Recommendation Report for Planning Permission for Works or Extension to a Dwelling

REF NO: BN/130/21/HH

LOCATION: 34 Highview Road
Eastergate
PO20 3XB

PROPOSAL: Erection of single storey rear extension, first floor side extension including the installation of 1 x rear dormer and part garage conversion to habitable use

Existing and Proposed
Block Plans

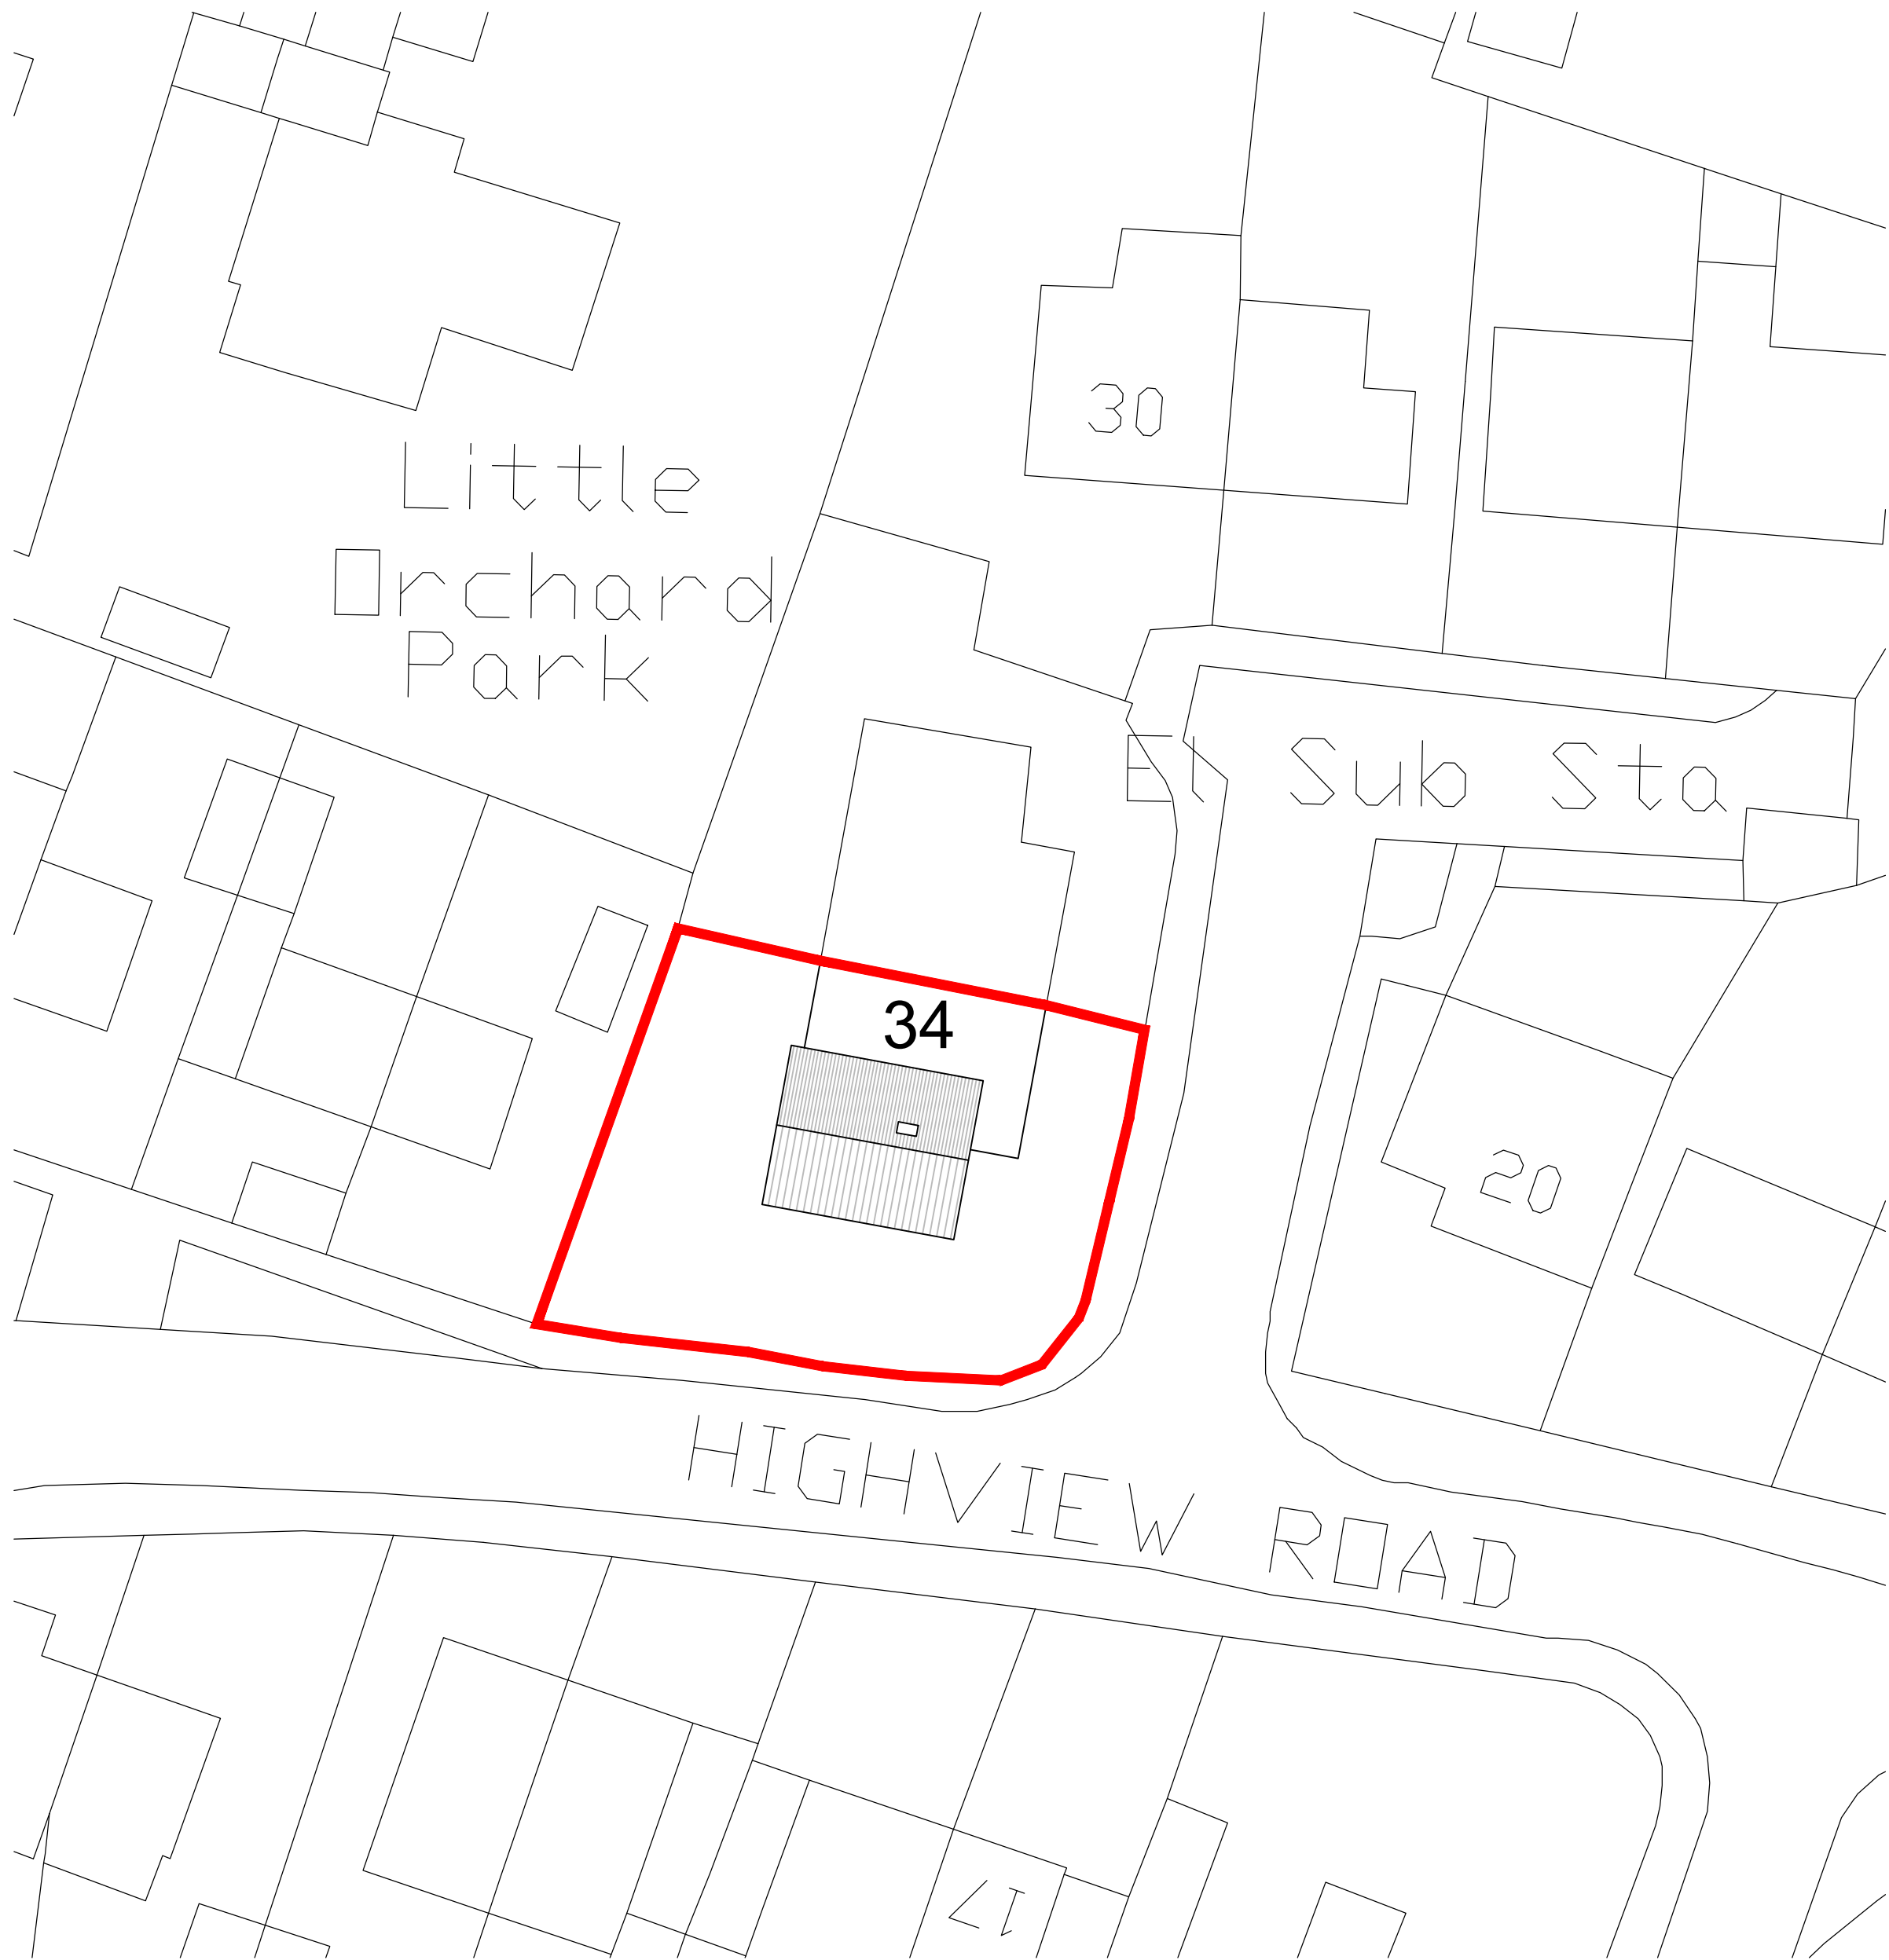
The part conversion of garage to habitable use will reduce the garage area available. However there seems to be space on driveway for at least 2 cars remaining so complies with policy T SP1 of the Arun Local Plan and ADC Parking Standards.

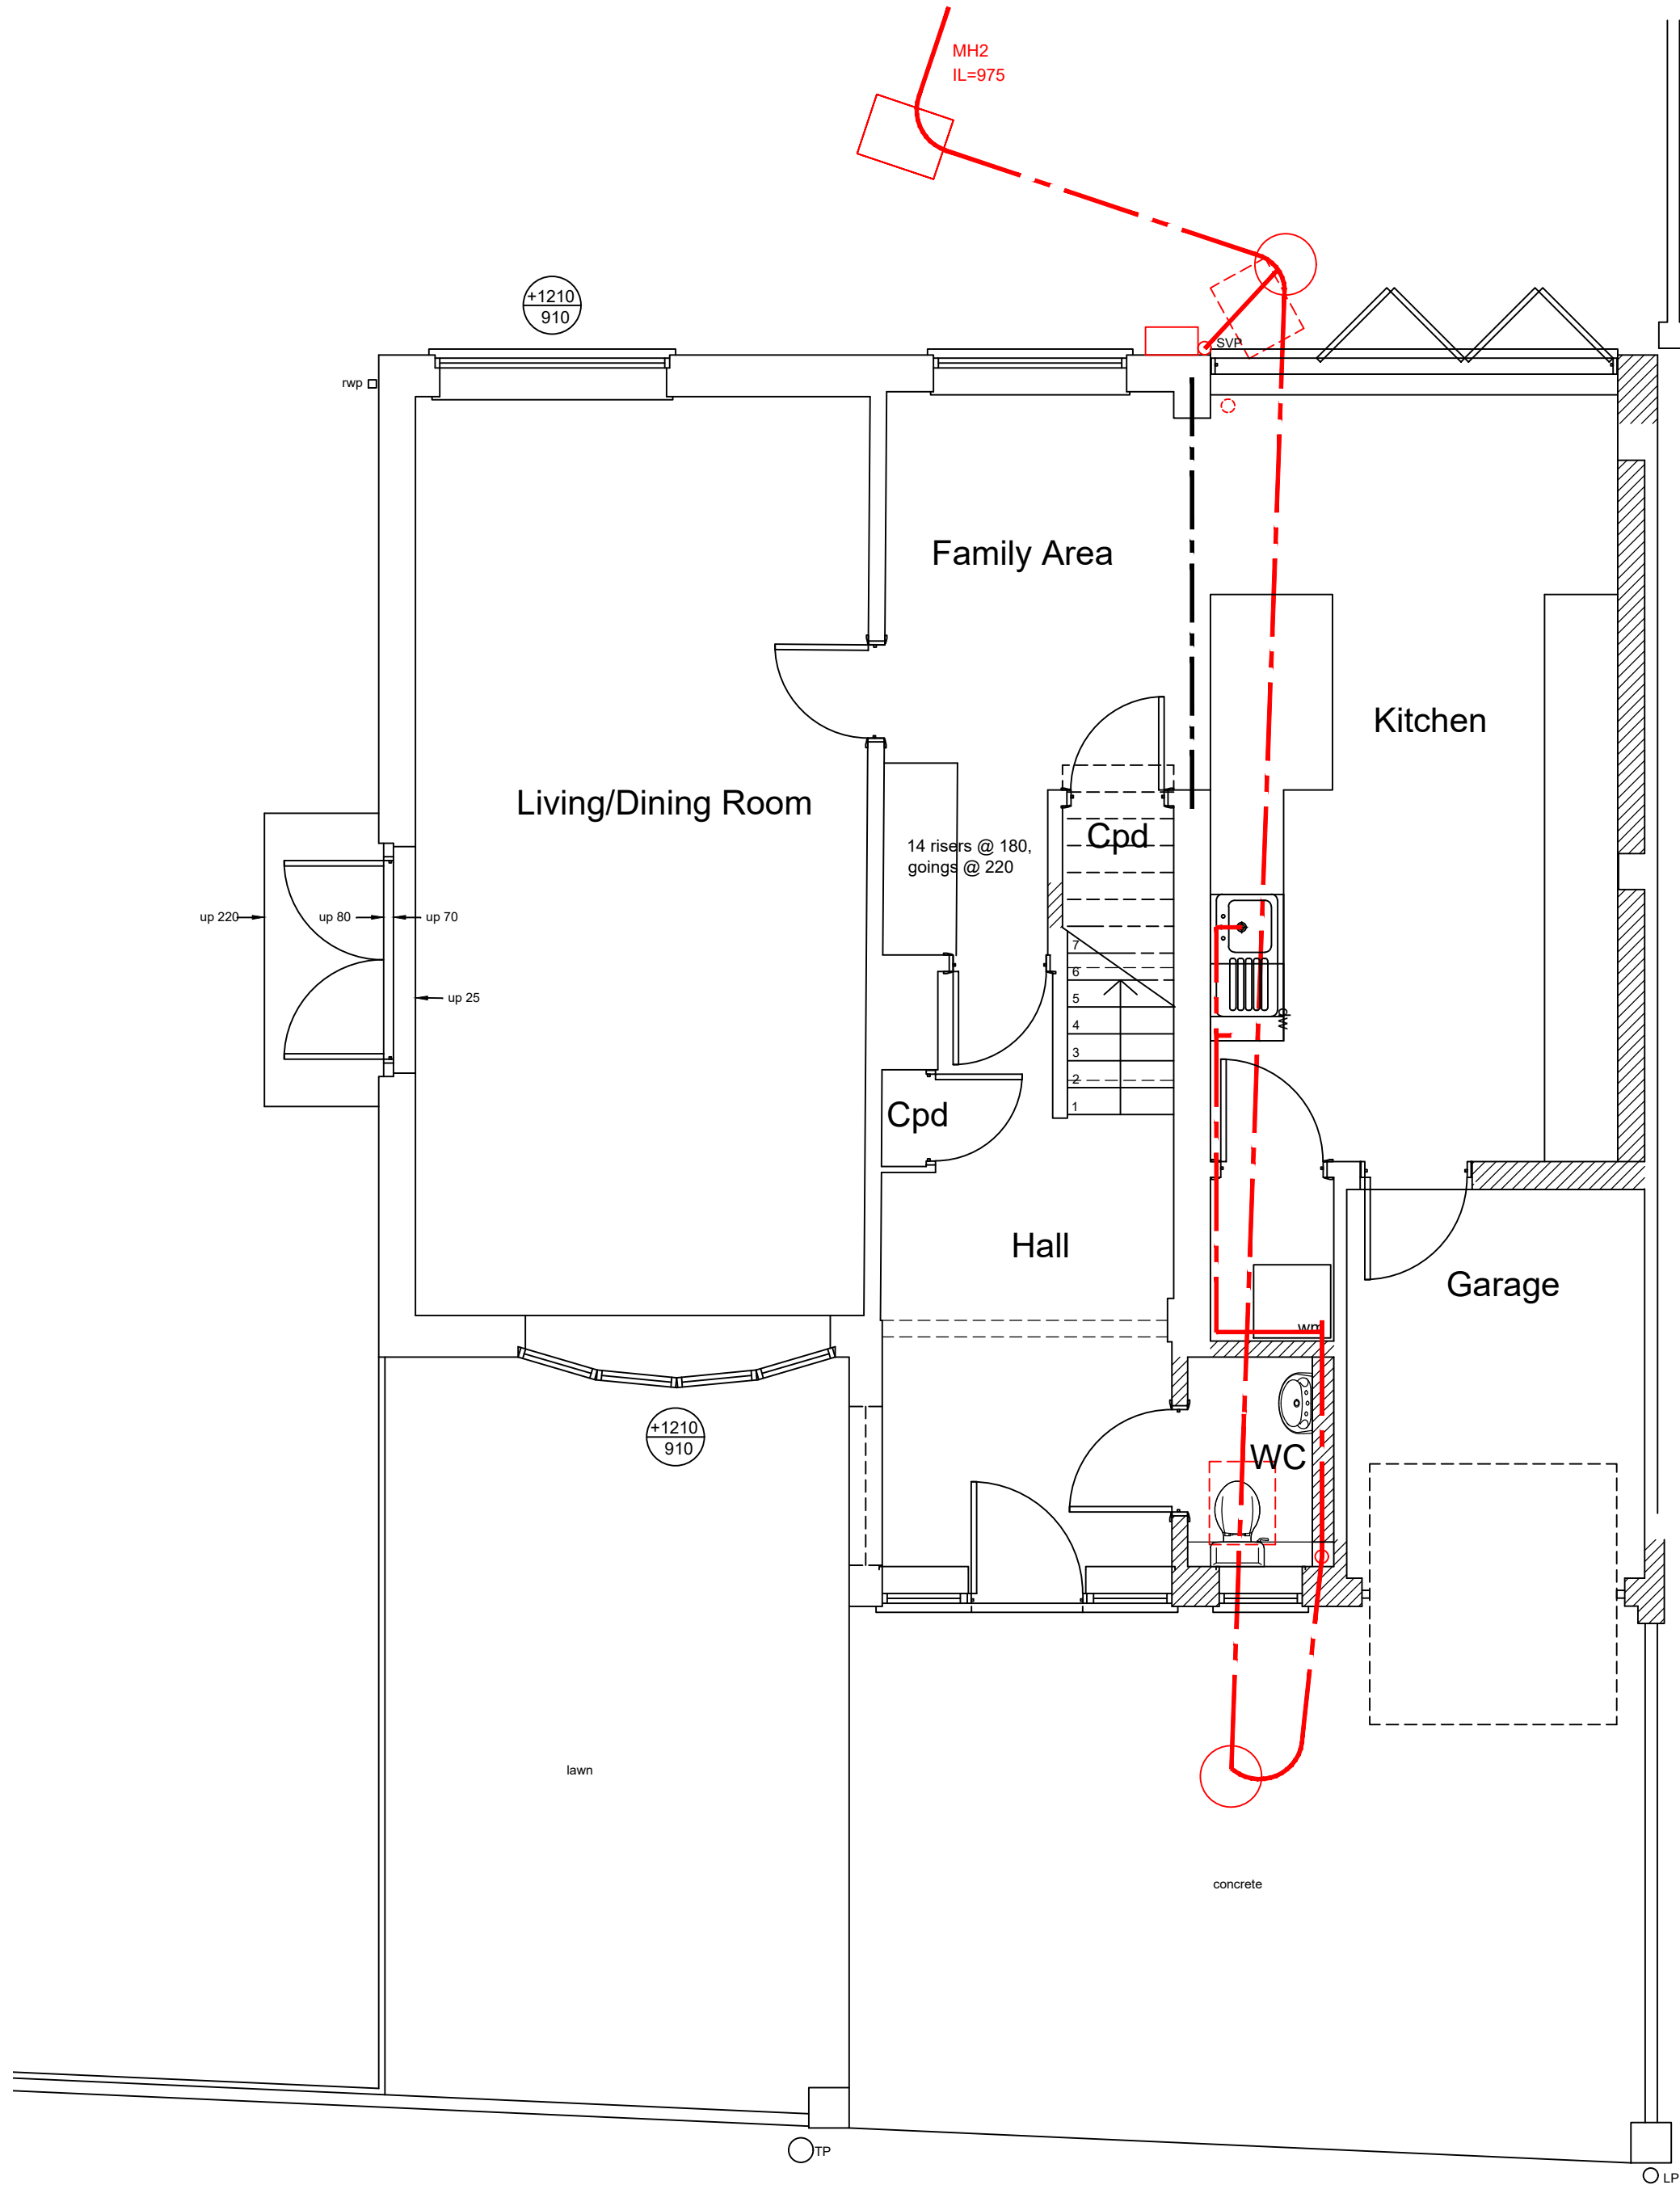
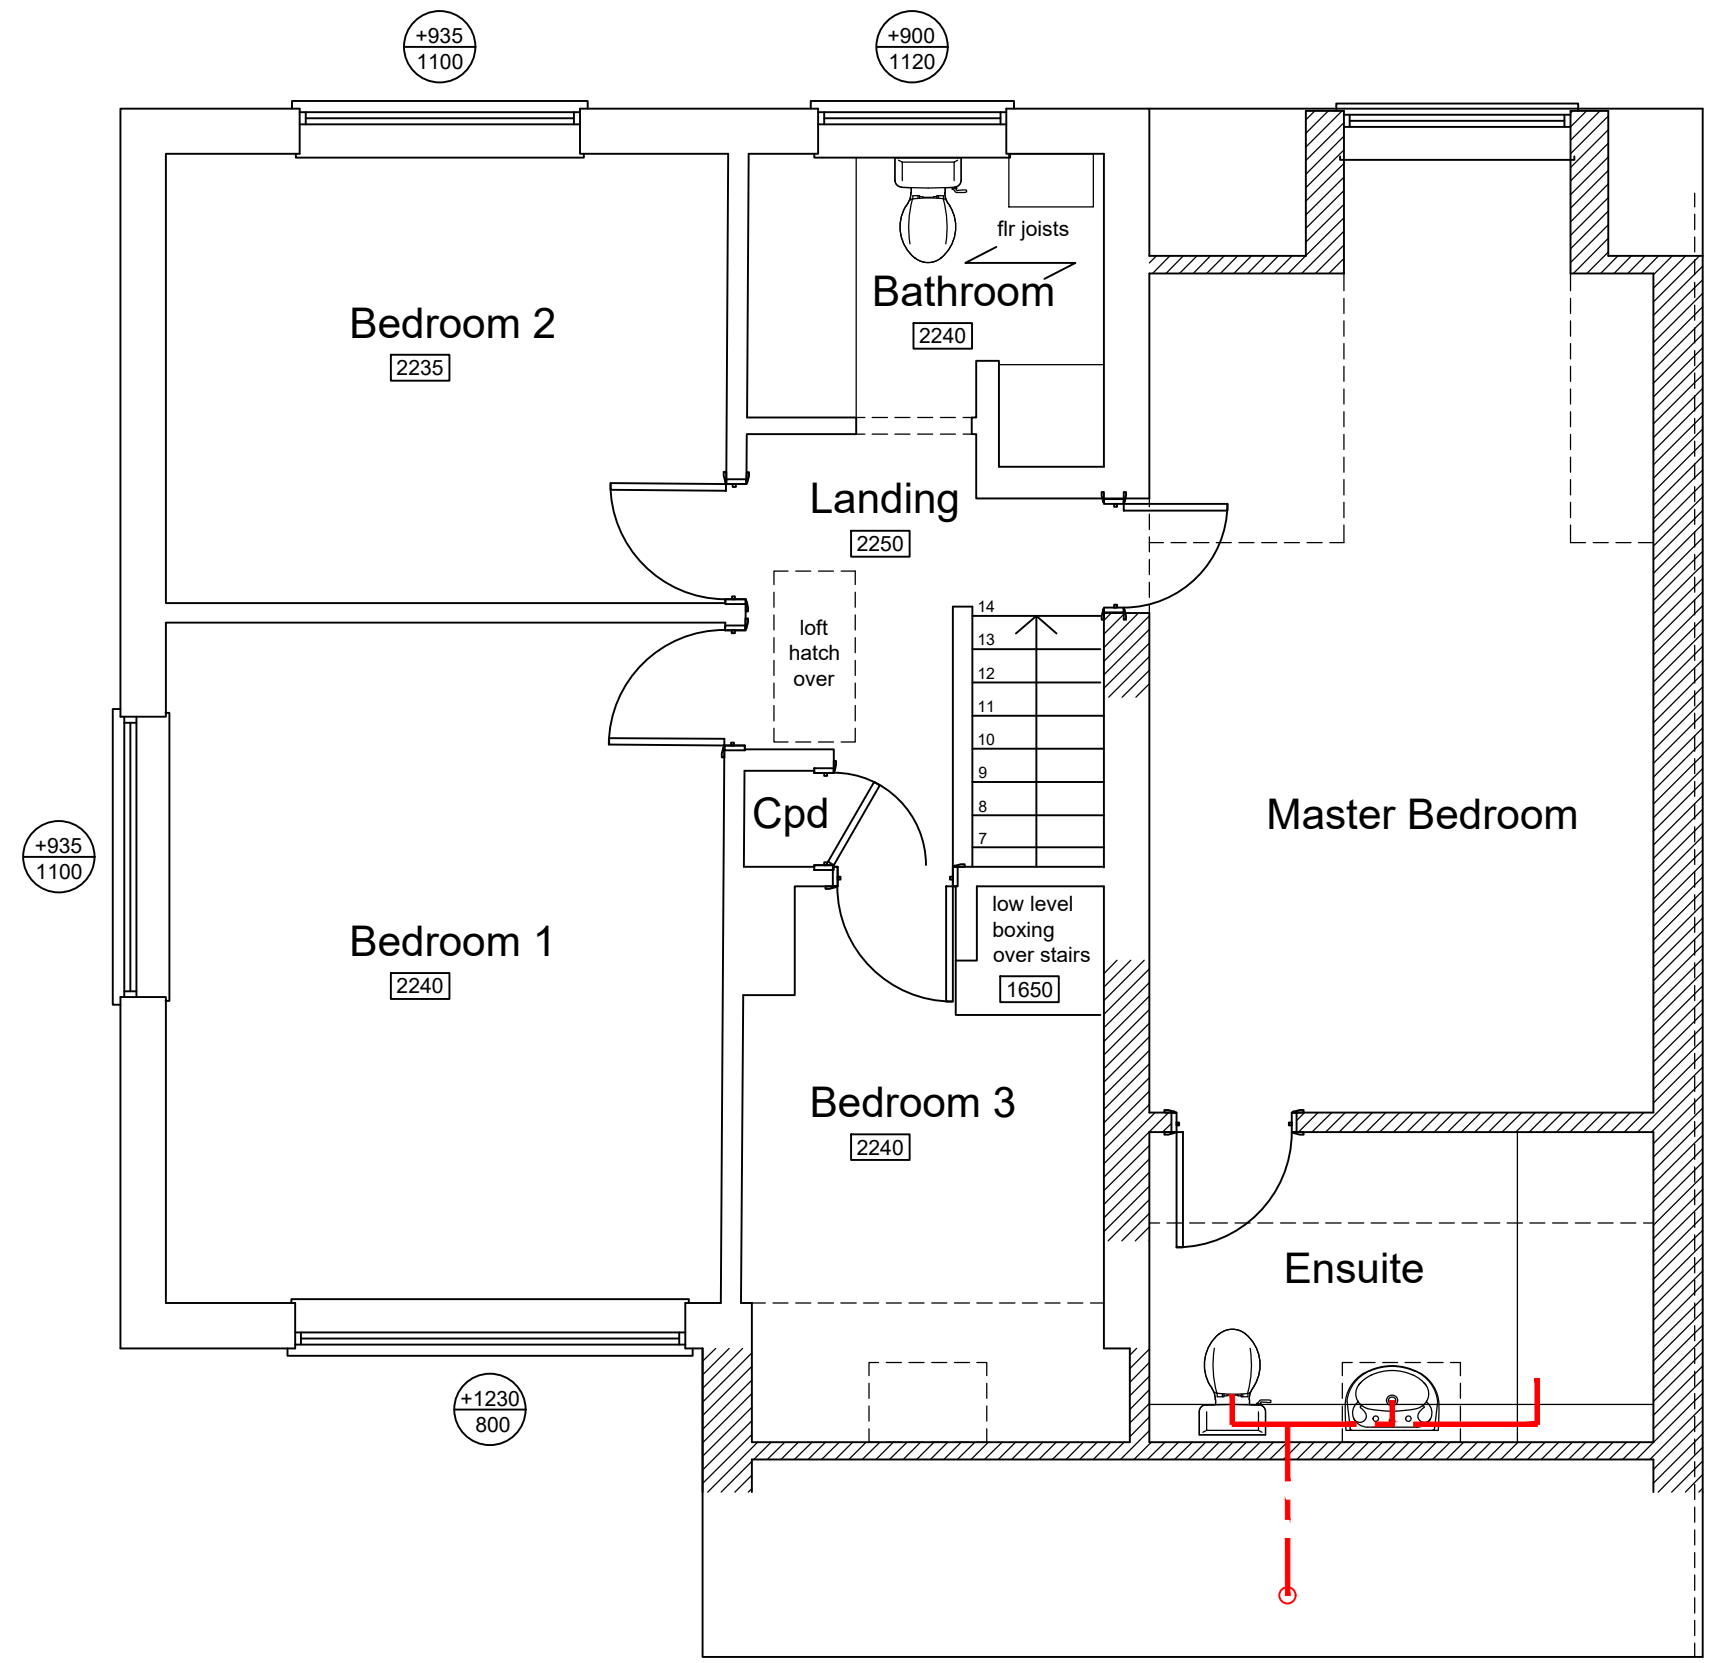
The proposed first floor side extension will be sited to the north side elevation and will run over the top of the existing attached garage to front (east) so will be highly visible from street scene. It is a large addition which adds significant bulk to the side of the property and is not subservient to the main dwelling in conflict with policy D DM4 of the Arun Local Plan.

The proposal will have the same width and depth as existing bedroom / garage to ground floor north side. The height to top of pitched roof will be approximately 6.96m.

There is approximately 4.18m retained to the east and 5.58m to the west boundary.

The proposal will form a new bedroom and en-suite bathroom at first floor. There will be two new roof windows to front (east) roof plane.

The proposed dormer will be sited to the rear (west) elevation at first floor. The dormer will measure approximately 2.57m wide x 3.30m deep x 2.10m high. It will contain one new window (2 window panes) facing west.

The proposed single storey rear extension will replace the existing ground floor bedroom to north west corner of property with a new kitchen. It will retain the same footprint as existing bedroom but will extend in length to rear so it will be in line with the existing rear elevation of property. Due to siting to rear (west) it will not be visible from street scene so does not adversely impact character of surrounding area and complies with policy D DM1 of the Arun Local Plan.

There will also be internal changes to convert part of garage to habitable use.

The proposal will have one new set of French doors (4 panes) to rear (west) ground floor elevation.

The proposed first floor side extension will increase overshadowing or overbearing to neighbouring amenity number 32 to north however due to no. 32's garage directly to northern boundary and gap to neighbouring property there is no adverse harm caused so is acceptable.

Due to two new roof windows to front (east) there is no harm to neighbouring amenity due to gap retained to front boundary and properties to front separated by road so is acceptable.
